Littlehampton Town Council
Mr P Herbert
Manor House
Church Street
Littlehampton, W Sussex
BN17 5EW

Your Ref: OWPC3653
Our Ref: LU/222/14/PL
Please ask for:
Simon Davis

4th September 2014

Application under Regulation 3 of the Town and Country Planning General Regulations 1992 for erection of 3No houses 2No flats and associated parking, hard and soft landscaping, on an existing parking court
Land North of 7-12 Joyce Close Littlehampton

Figure 7: Sound Level Meter Positions

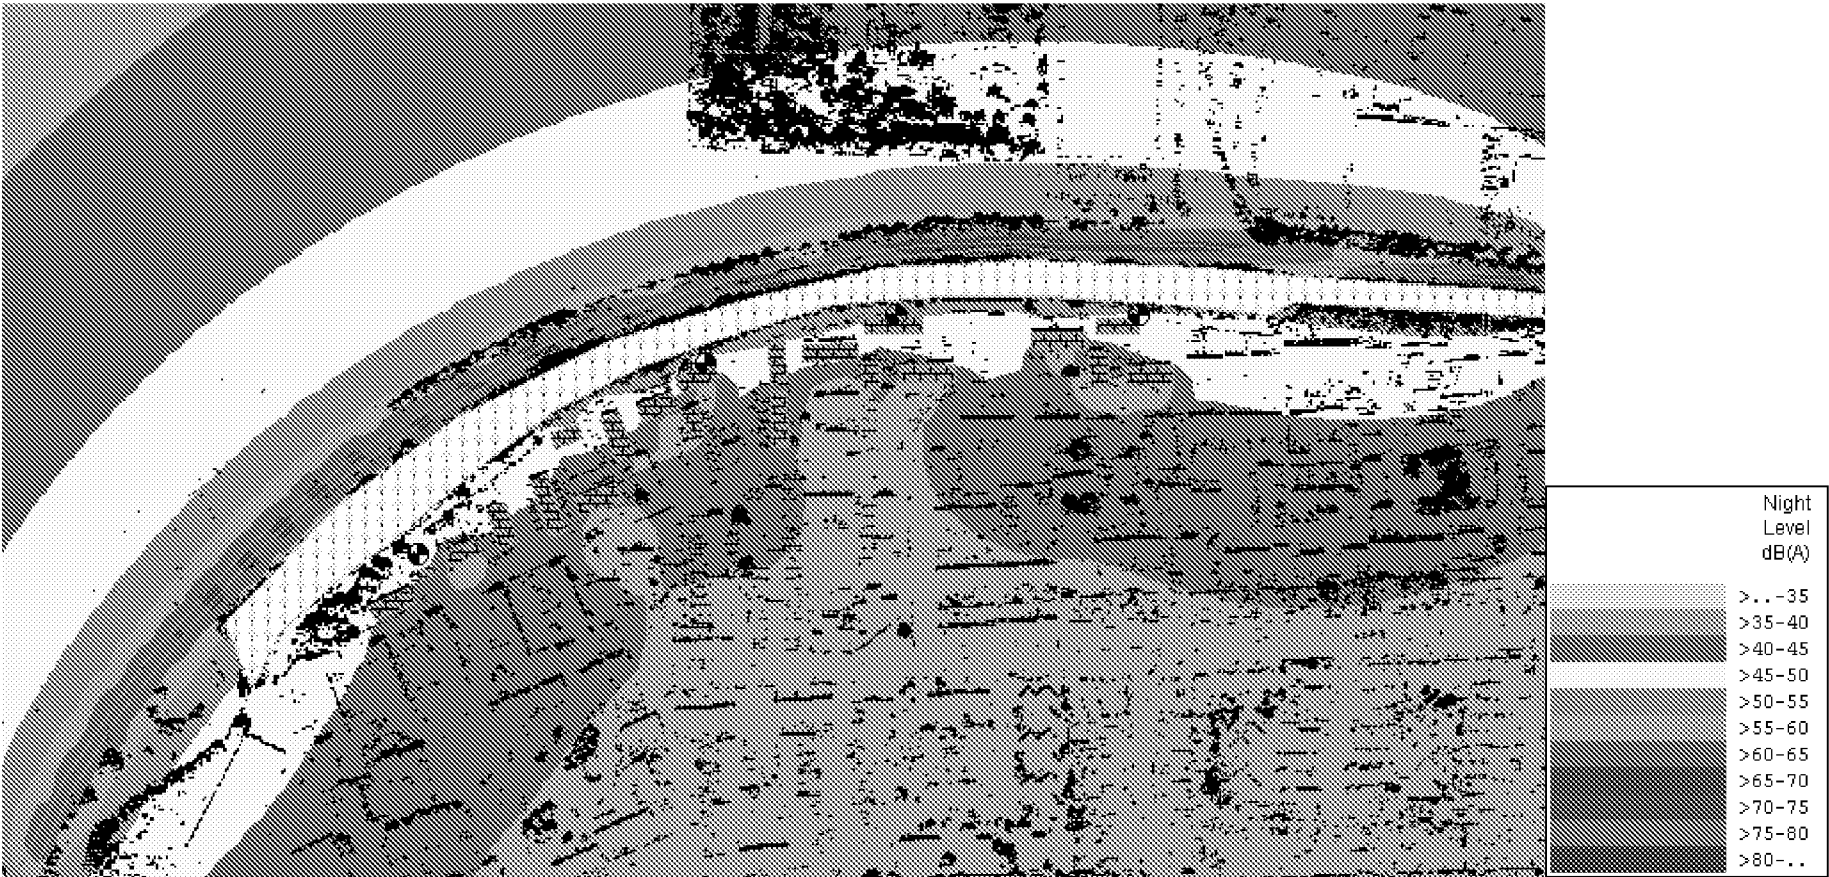
'The sites are subject to reasonably high levels of noise emanating from the nearby A259'

- *The majority of amenity areas will be subjected to levels of noise that would be unacceptable under WHO guidelines.'*

- *These conclusions particularly affect houses that face towards the north and have very small front gardens*
